SICEEP, The Haymarket – Response to Transport for NSW Submission

Note: It is acknowledged that additional feedback has been received following the submission of the Transport & Traffic Addendum for SSDA1 requesting further information (ARUP letter dated 9 July 2013). Hyder and the proponent will review and consider this request in the context of The Haymarket and respond under separate cover to The Department of Planning & Infrastructure.

Figure 44 – Site Access and Parking

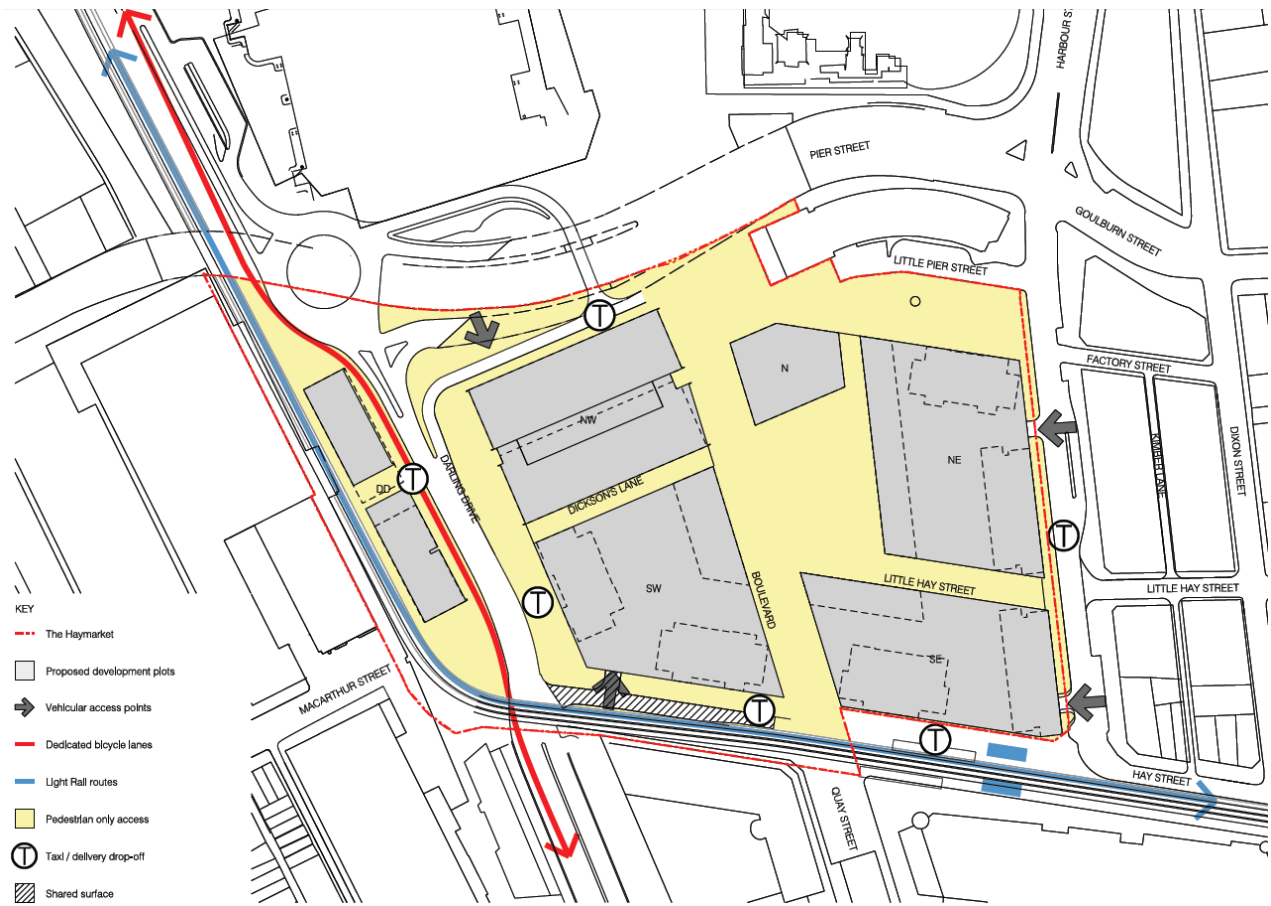
Traffic Analysis	The proposal will now force vehicles leaving both the proposed Haymarket carpark (400 spaces) and Theatre carpark (107 spaces) to travel southbound towards Ultimo Road. Yet, there is no traffic analysis (either	Hyder has extended the AIMSUN model to incorporate the full length of Darling Drive. The model was extended from Quay Street to the Ultimo Road intersection. The Darling Drive/Ultimo Road intersection has been assessed for
